Re: Kairos Power Expansion
5201 Hawking Dr. SE
Traffic Circulation Layout
Architect's Stamp XX-XX-XX (Q16-DA5000A)

Based upon the information provided in your submittal received 07-26-22, the above referenced plan cannot be approved for Building Permit until the following comments are addressed:

D2
A-110

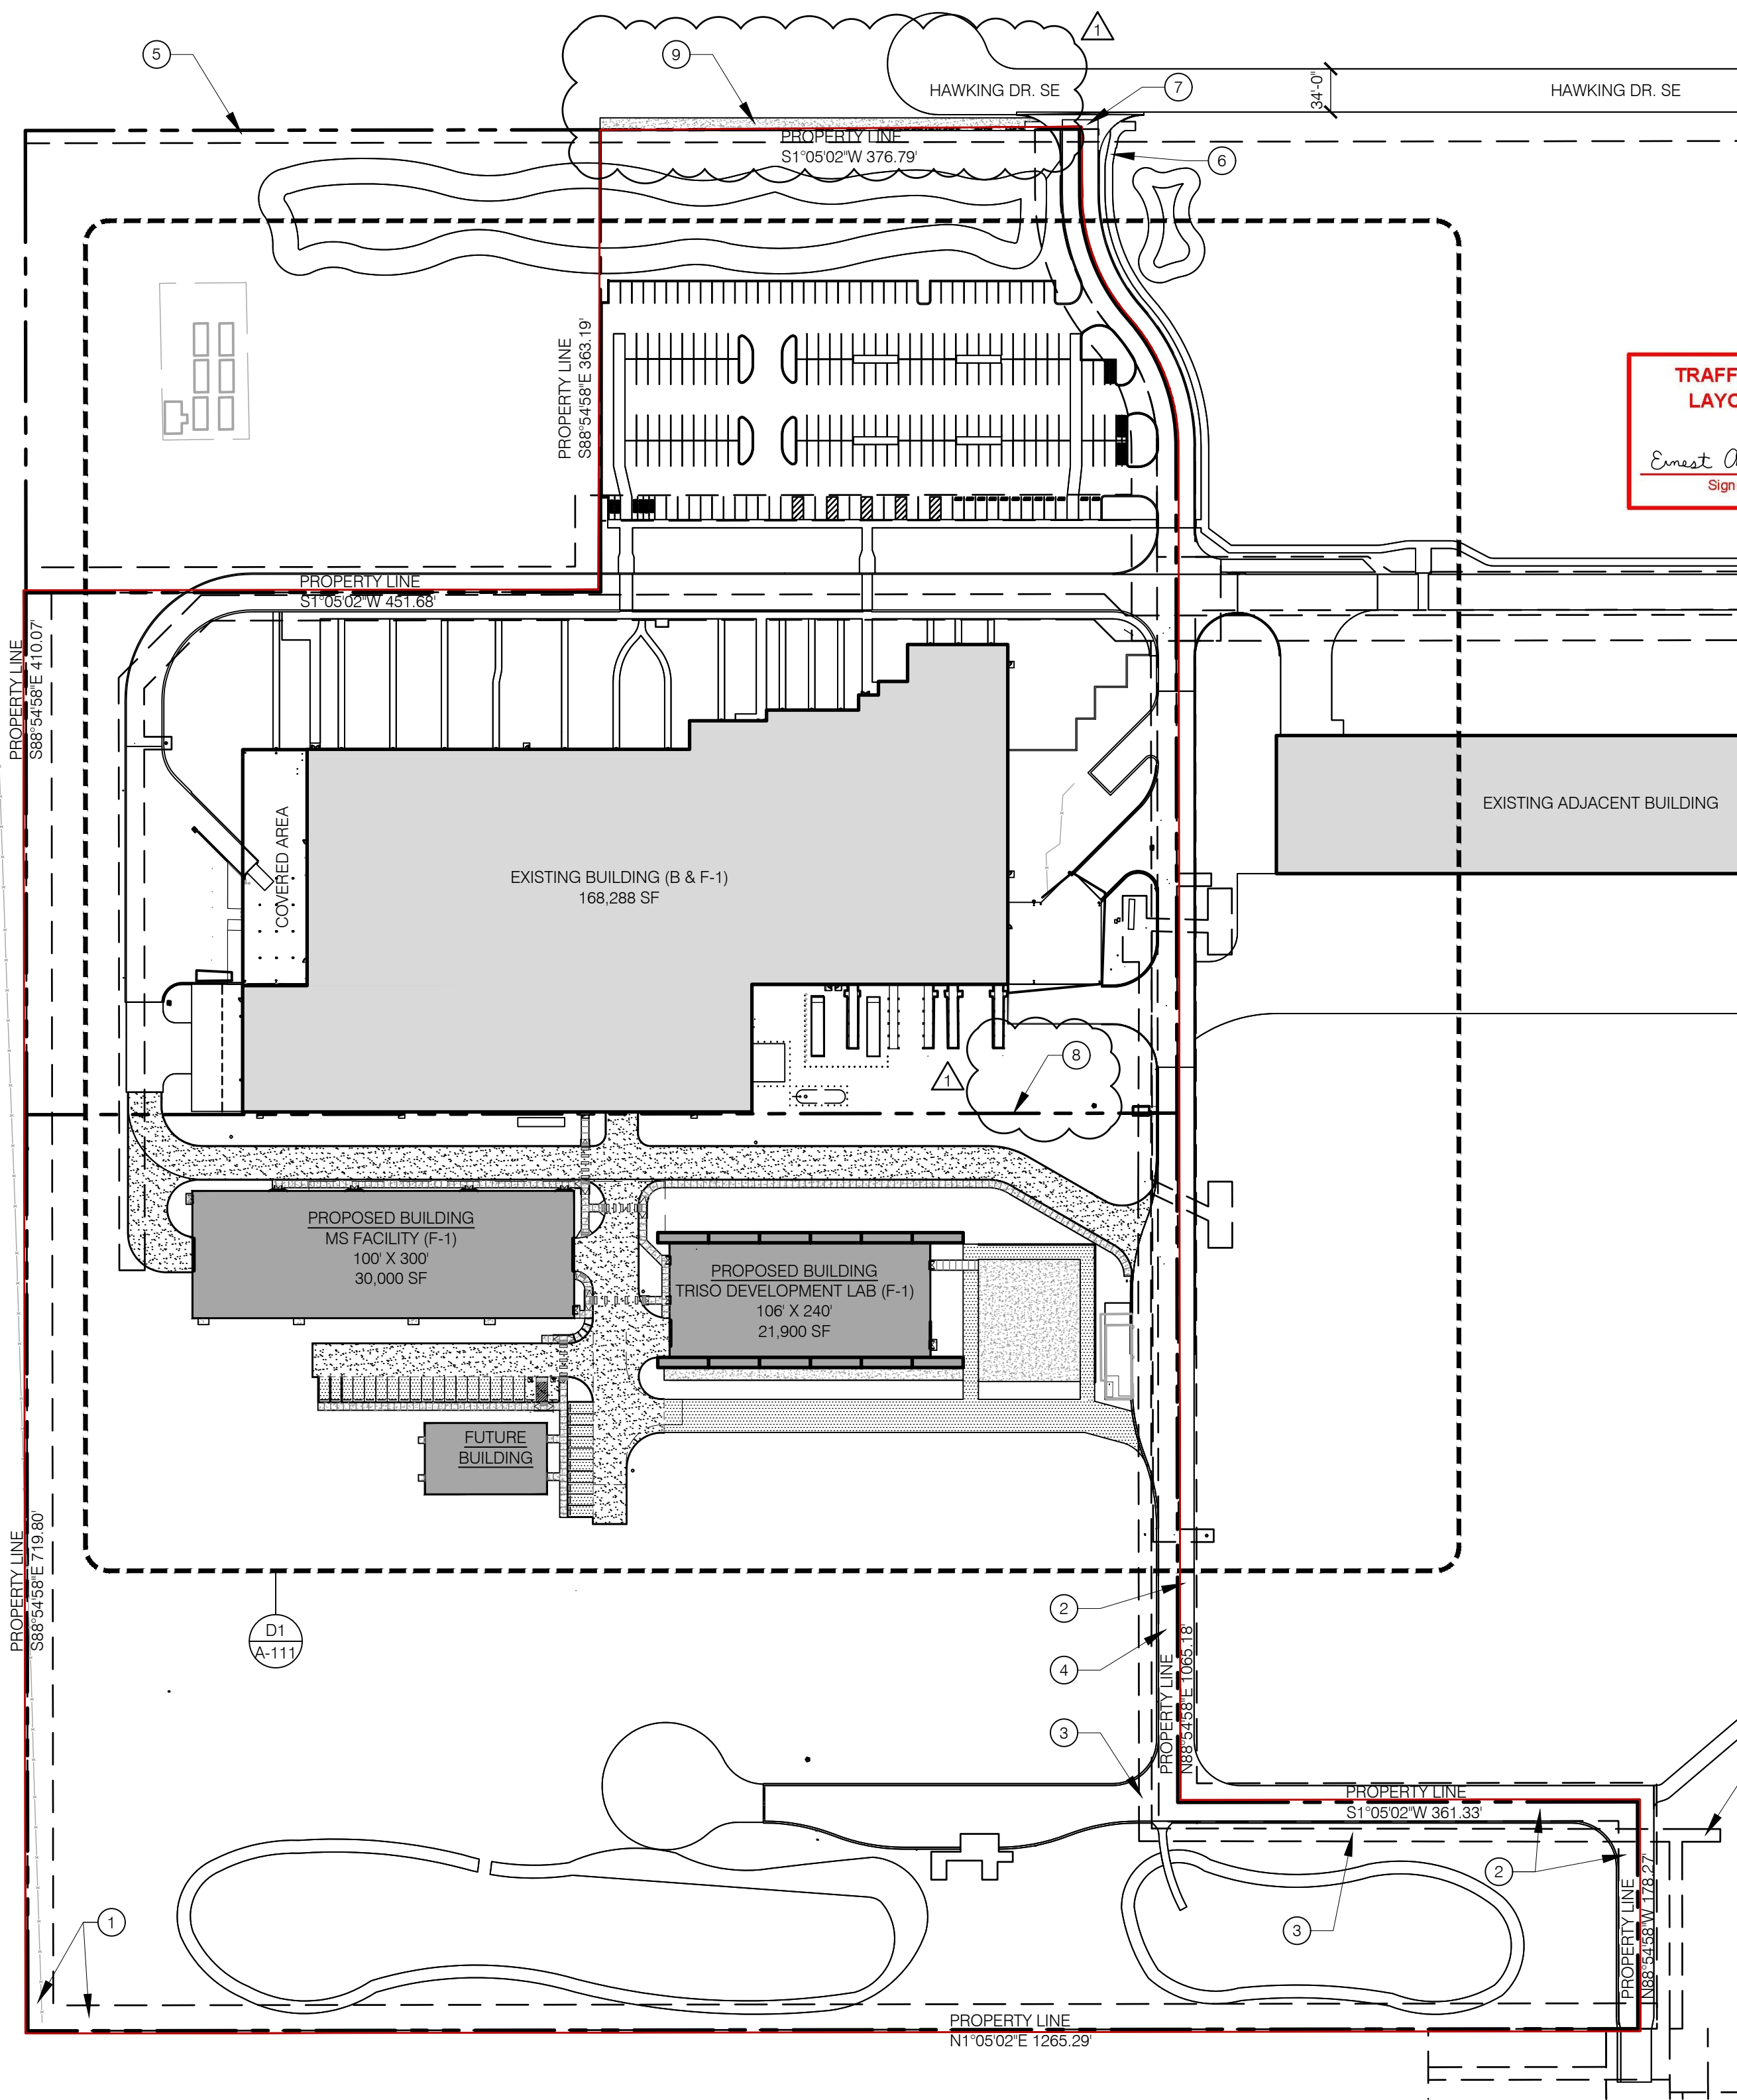
1. Clarify existing property lines and proposed property lines.
2. Please list the width and length for all existing and proposed parking spaces. Some dimensions are not shown.
3. The minimum parking stall dimensions are:

D1
A-111
ENLARGED SITE PLAN
SCALE: 1" = 50'

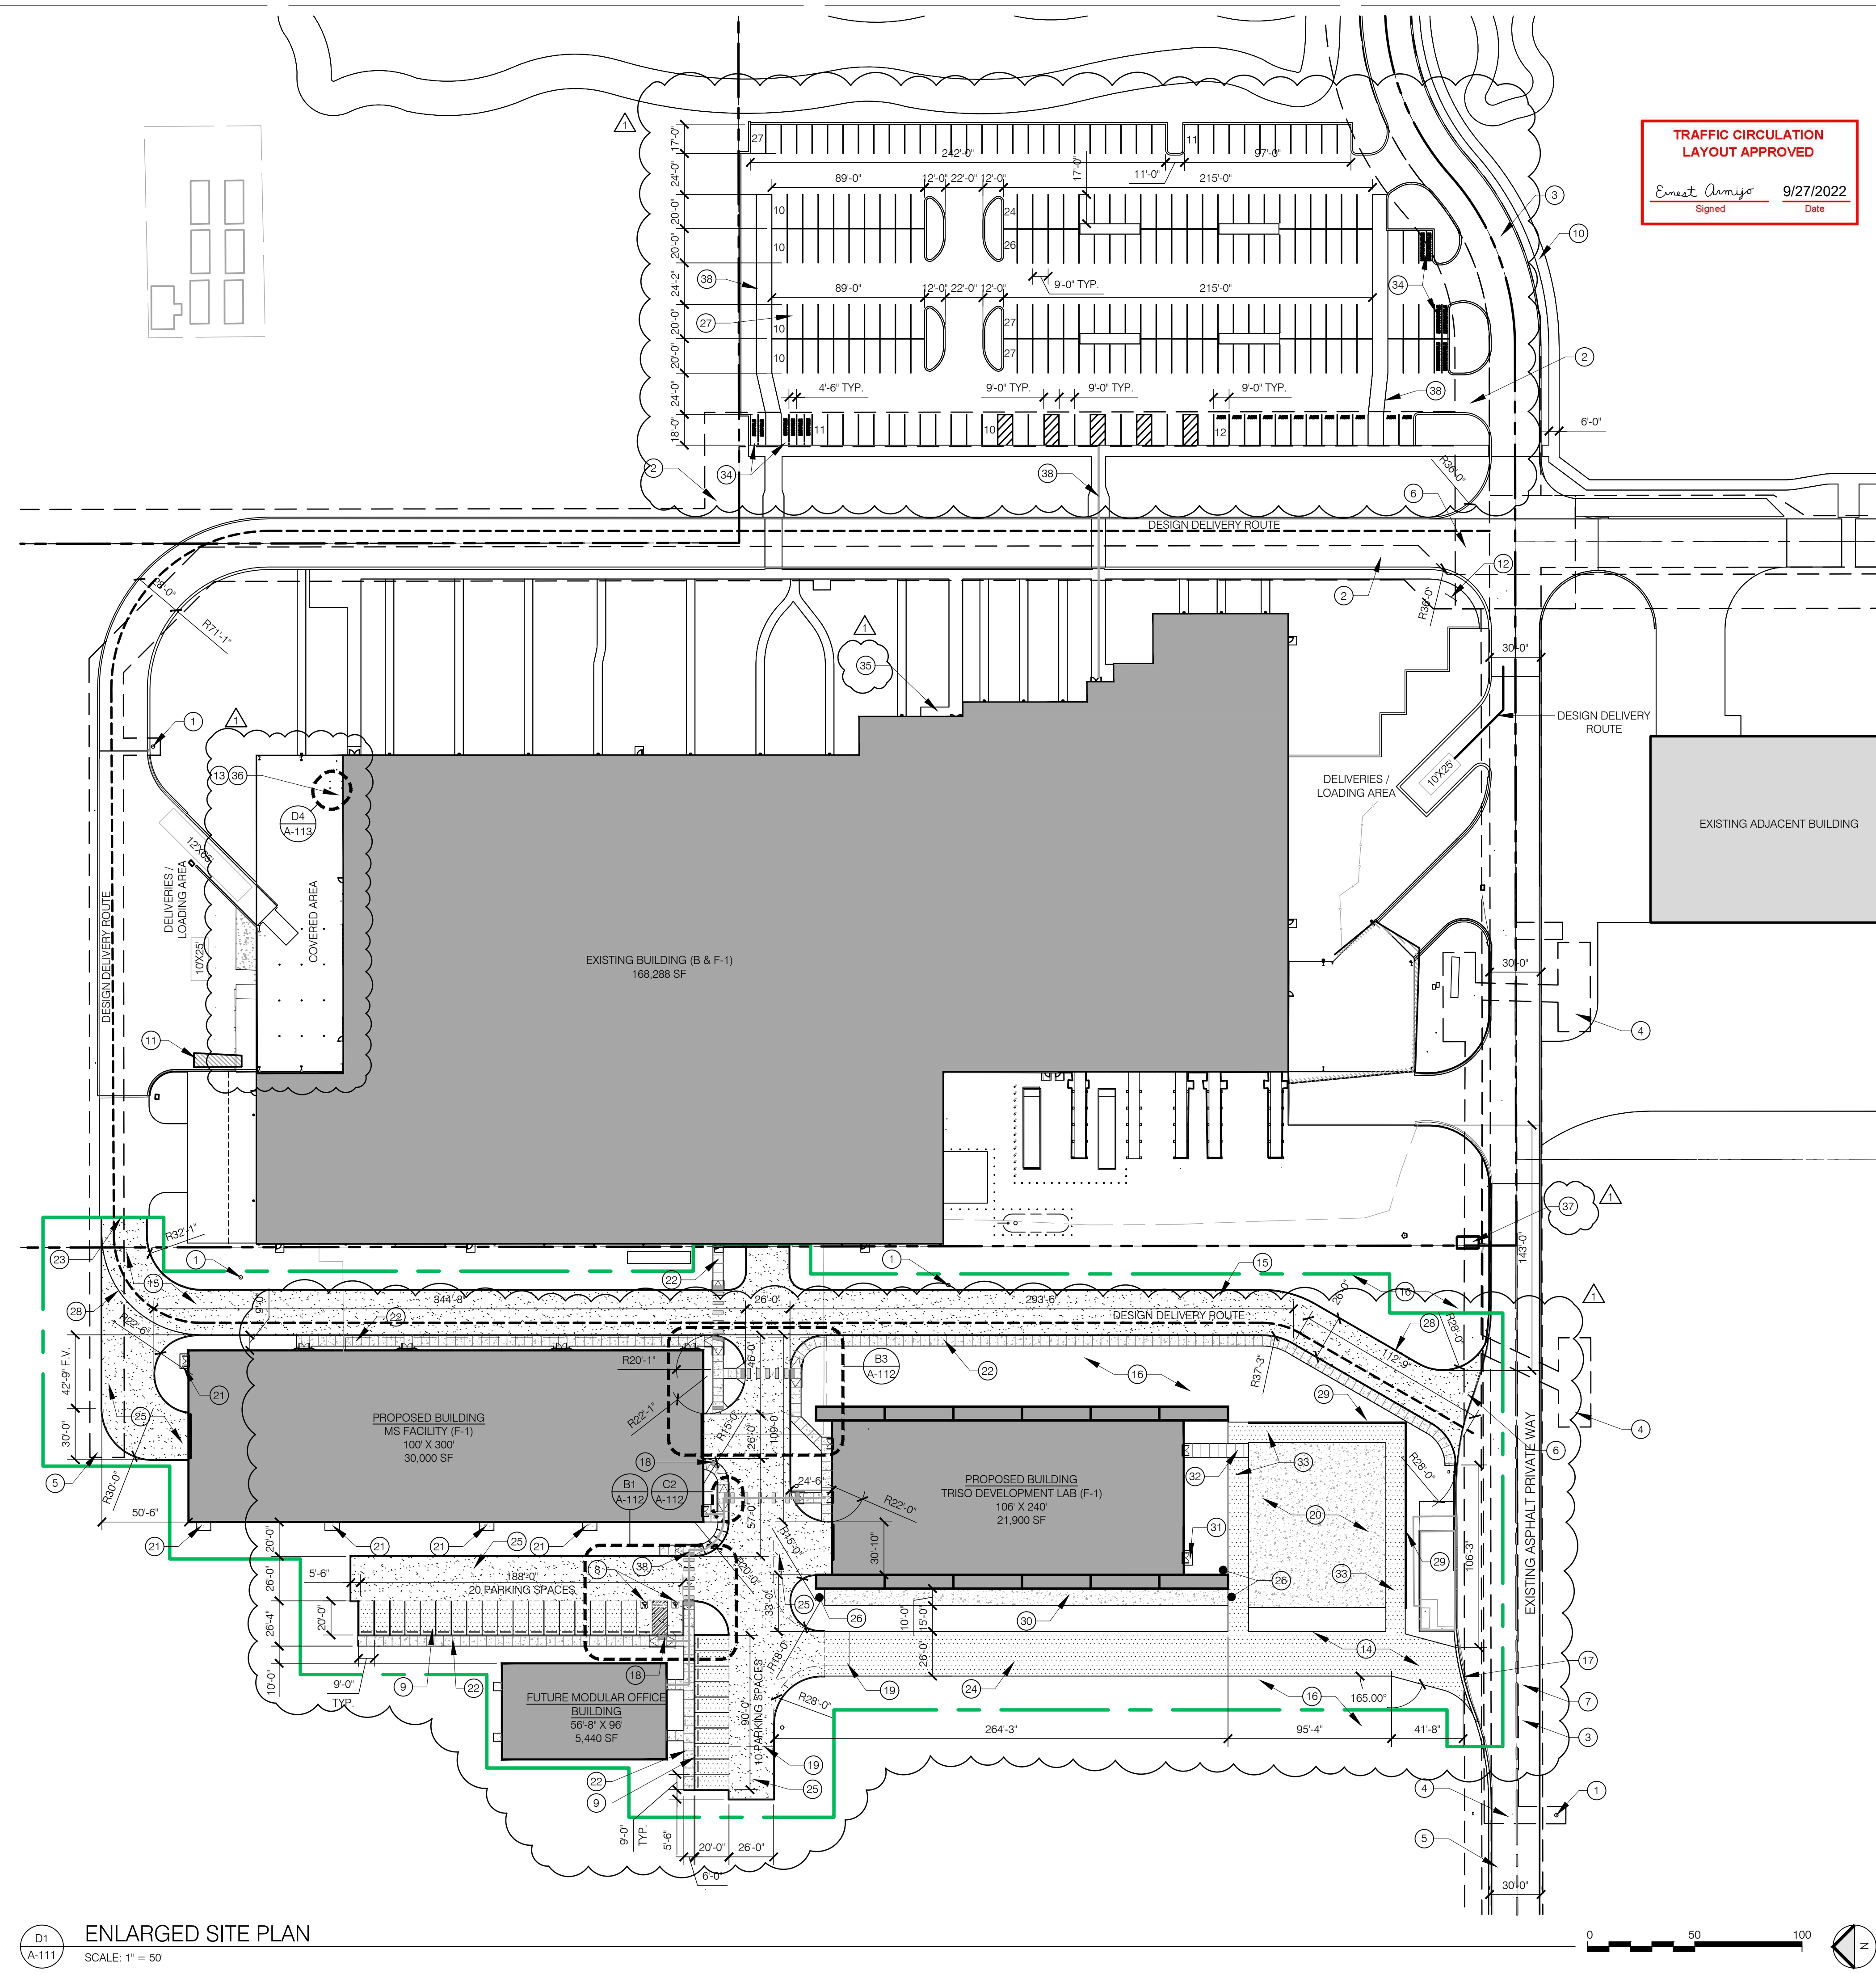
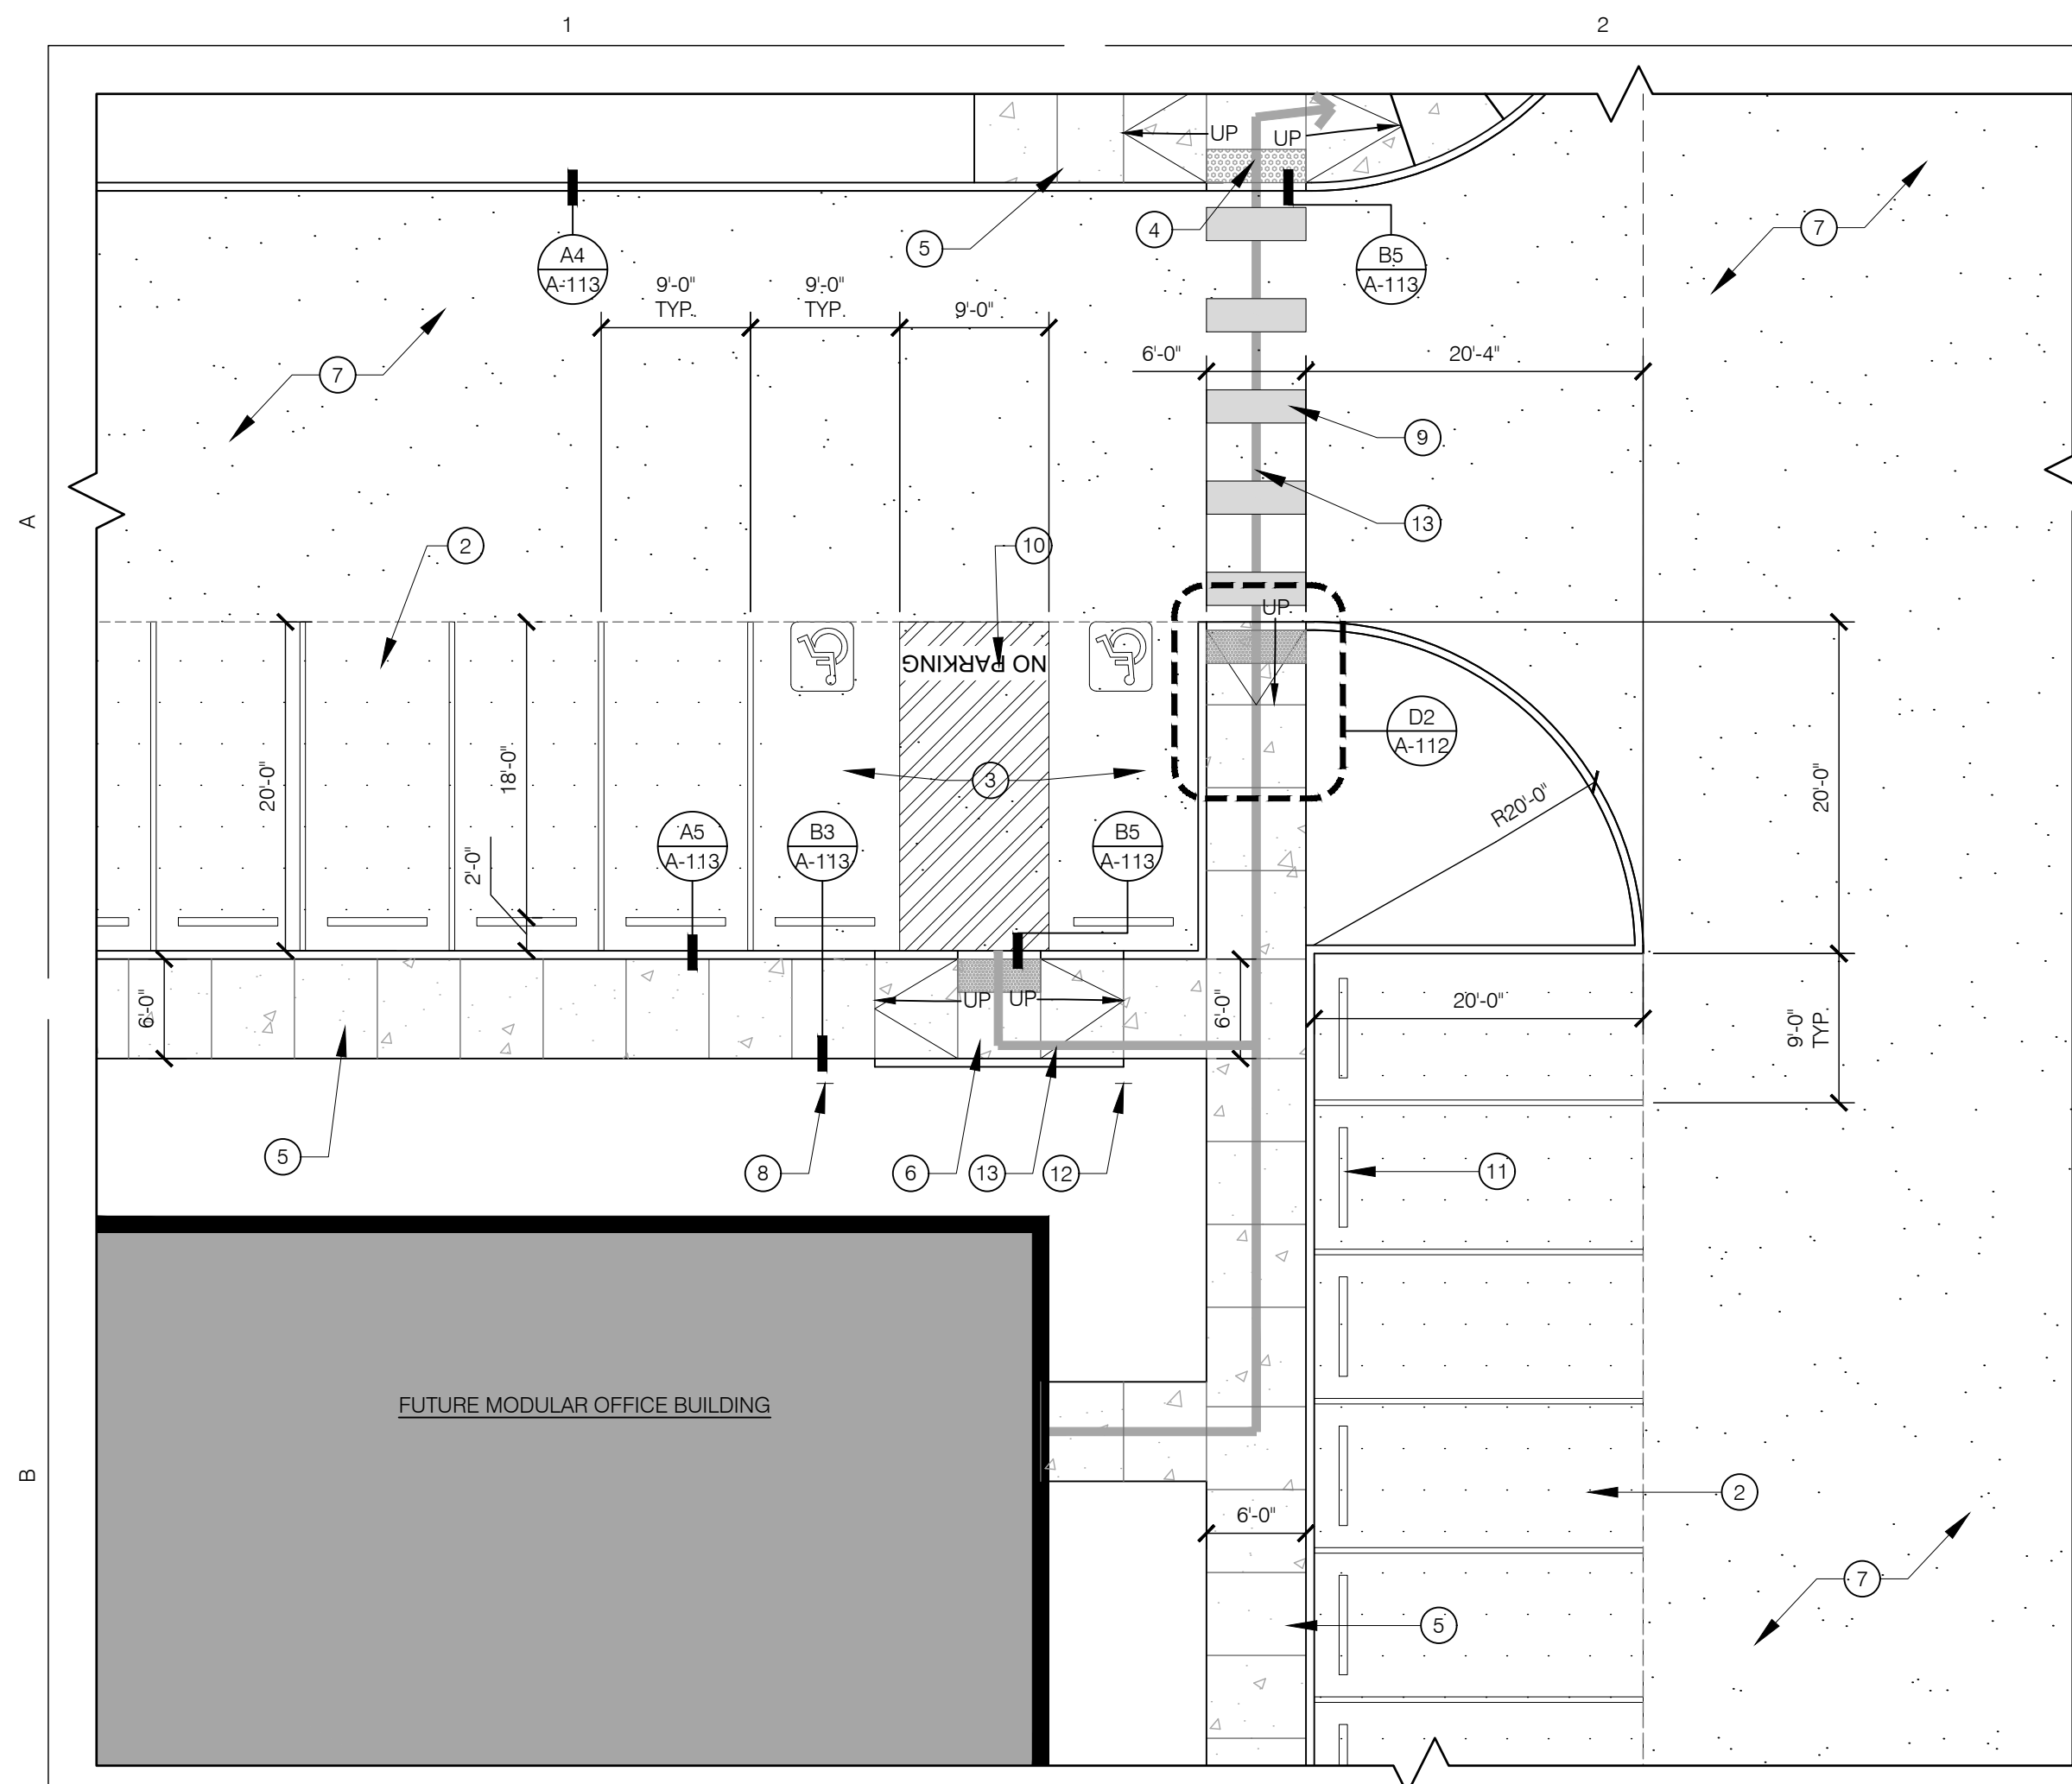
7. ADA curb ramps must be updated to current standards and have truncated domes installed.
8. Keynote 18: provide all proposed ramps details and reference COA std dwg.

9. Keynote 22: please reference COA std dwg 2430 for the proposed sidewalk.
10. Keynote 17: is this will be one way or two-way drive aisle?

17. Per the IDO, a 6 ft. wide ADA accessible pedestrian pathway is required from the public sidewalk to the building entrances. Please clearly show this pathway and provide details.

18. Per DPM, a 6 ft. wide ADA accessible pedestrian pathway is required from the ADA parking stall access aisles to the building entrances. Please clearly show this pathway and provide details.
